Consultation Response from KC, Ecology Unit		
2020/93954 Land at, Lingards Road, Slaithwaite, Huddersfield, HD7 5HY		
Erection of 57 dwellings and associated works		
Date Responded: 21/12/2020	Responding Officer: Amy Reddick	Responding Ref:

Adequacy of ecological information

Project	Housing at Lingards Road, Slaithwaite			William Best RIBA
Client	SB Homes Ltd			The Chapel House
Drawing	SITE PLAN 3			22 Pole Gate
Scale	1:200	Date	13/10/2021	Scammonden
Dwg No	2019 572 52	Rev	E	West Yorkshire
				HD33FW
				Tel 01484 845896

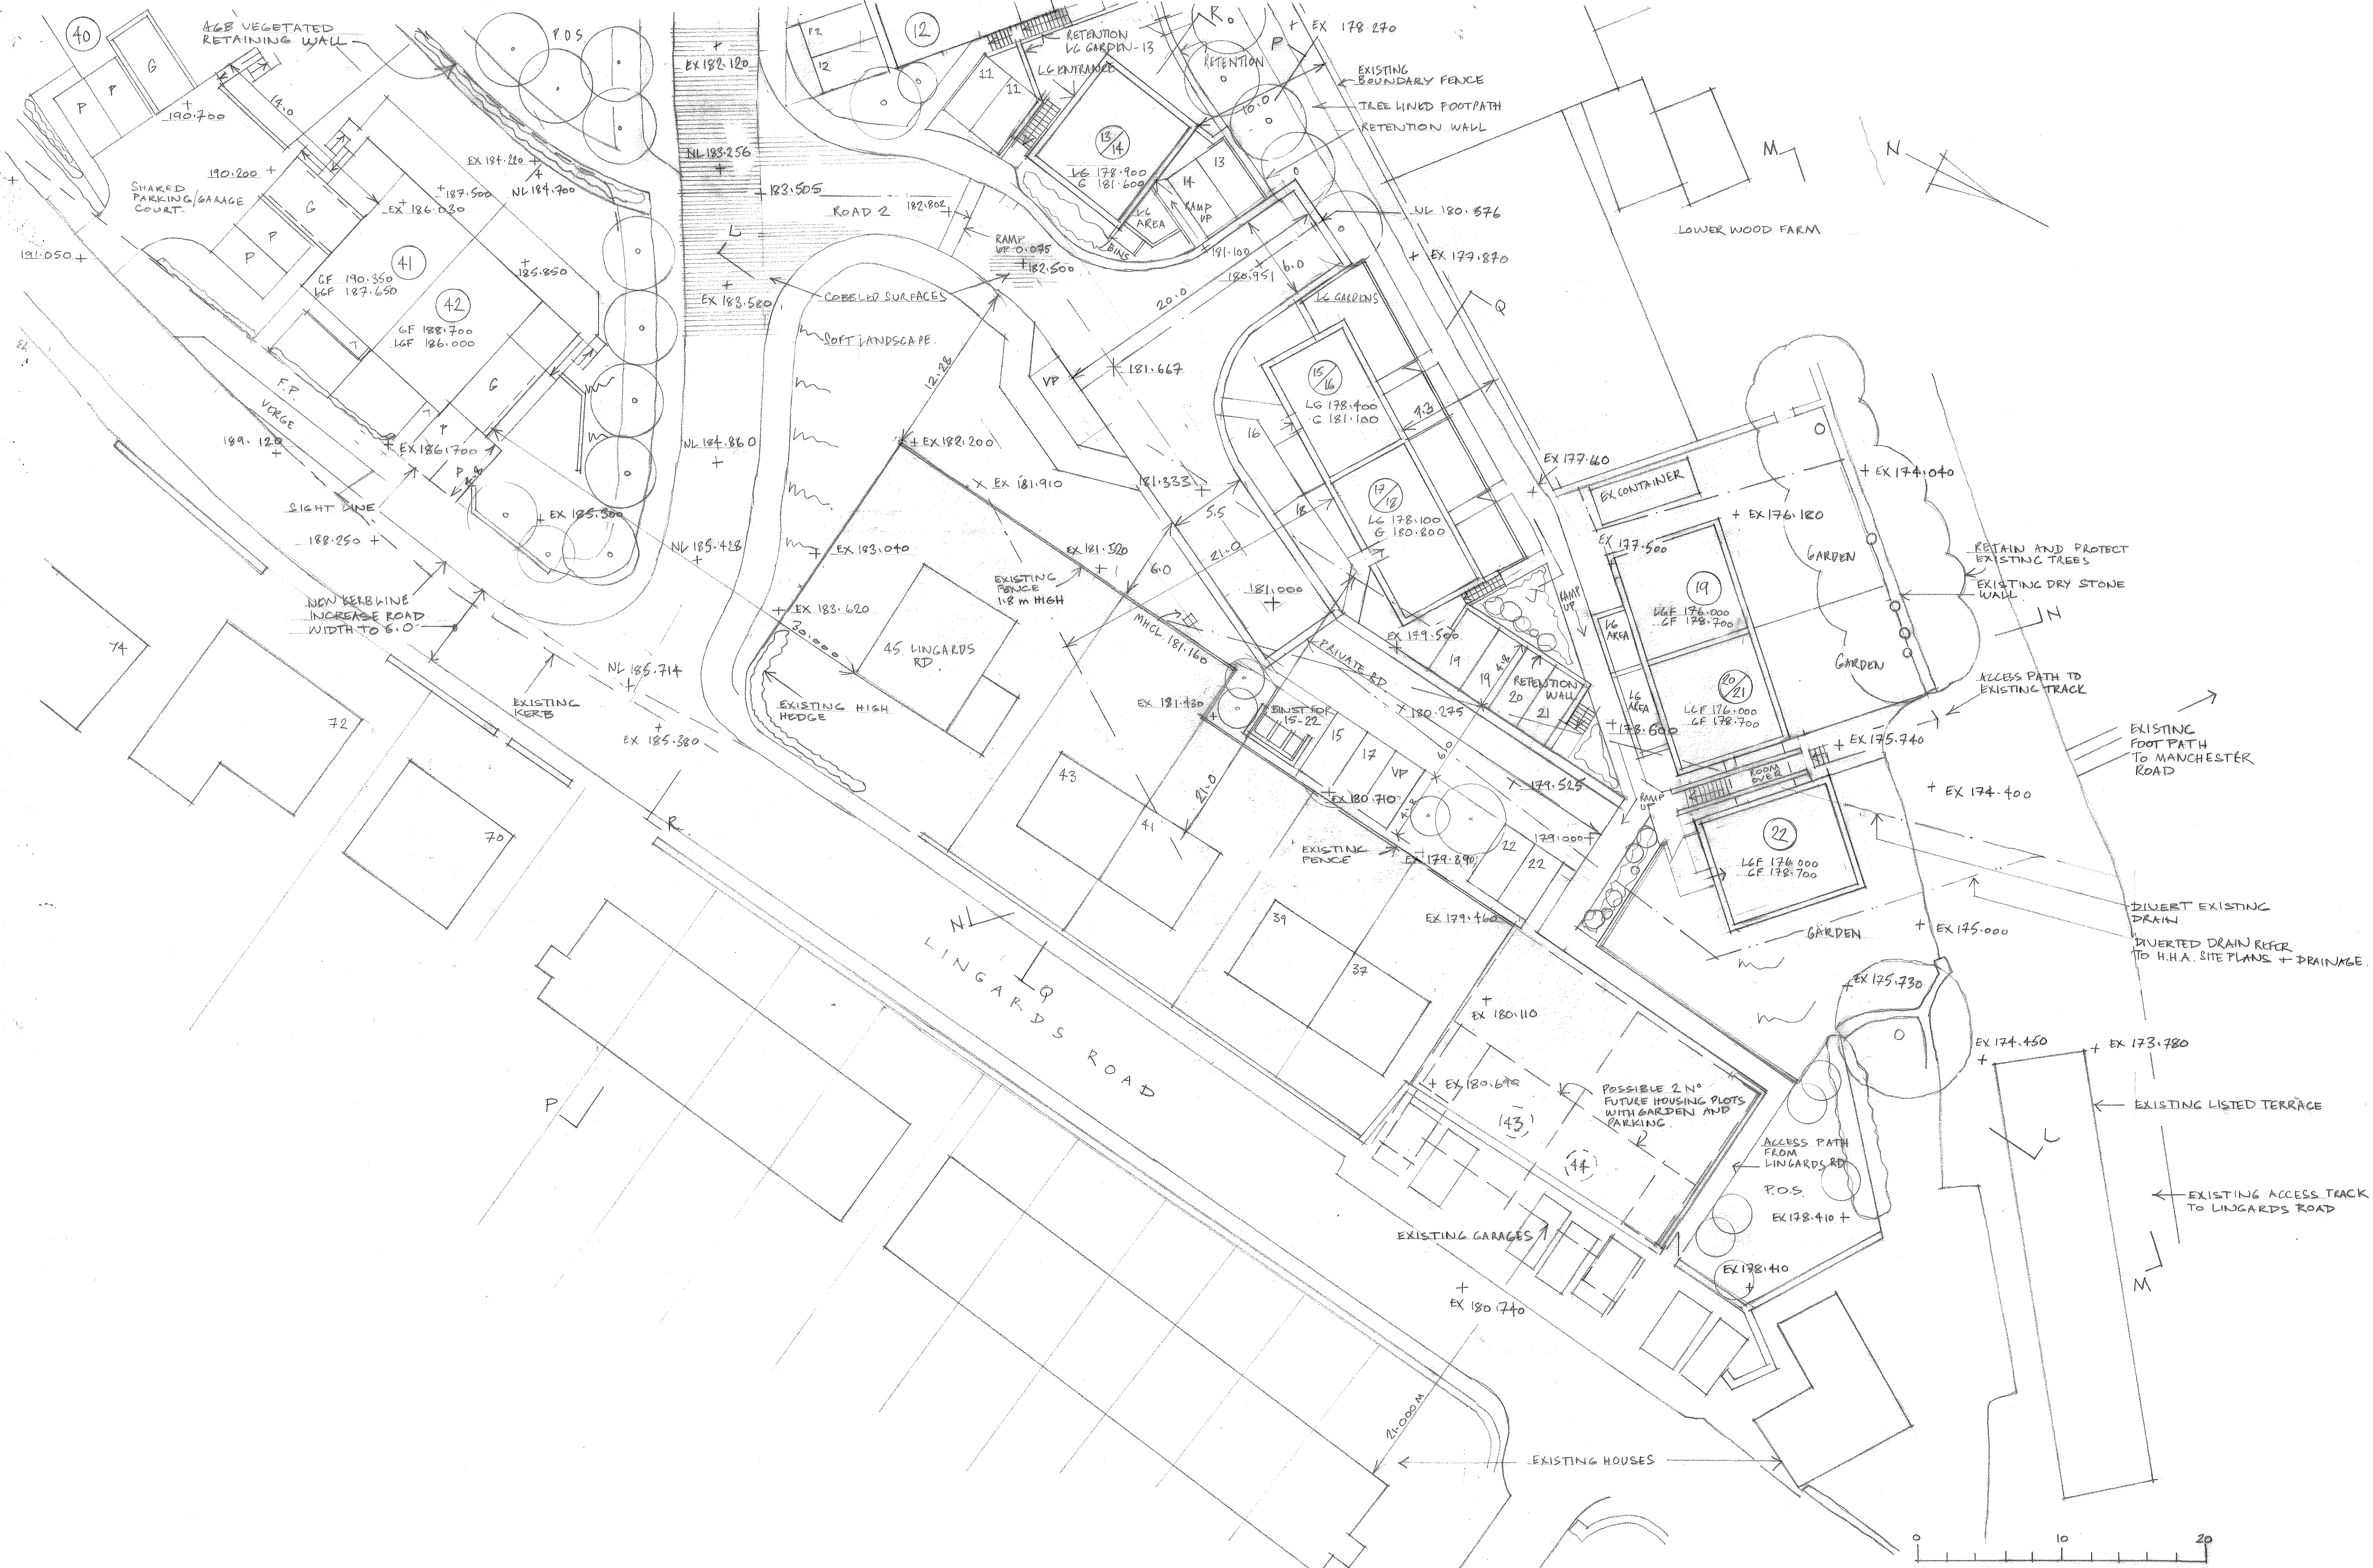
It is noted that the watercourse is to be retained post-development which is an improvement upon on the outline application and in line with previous comments made by KC Ecology in 2015. However, the watercourse appears to be partially culverted to facilitate the proposed layout. No ecological assessment for how this may impact upon the ecological value of the watercourse has been provided. In addition, it appears that the watercourse will be included within the curtilage of the residential gardens and therefore it's future status and maintenance is uncertain. It would be preferable for the watercourse to be enhanced and managed post-development (perhaps through inclusion into a sustainable drainage scheme) and this is encouraged in order to increase the ecological value and contribute to a biodiversity net gain on the site.

- Clarification regarding whether the development site and off-site offsetting site are functionally linked to the South Pennine SPAs.
- Justification for selection of woodland habitat to provide biodiversity net gain rather than species-rich acid grassland.
- Further assessment regarding the culverting of the watercourse, potential enhancement and future management if included withing residential curtilages.
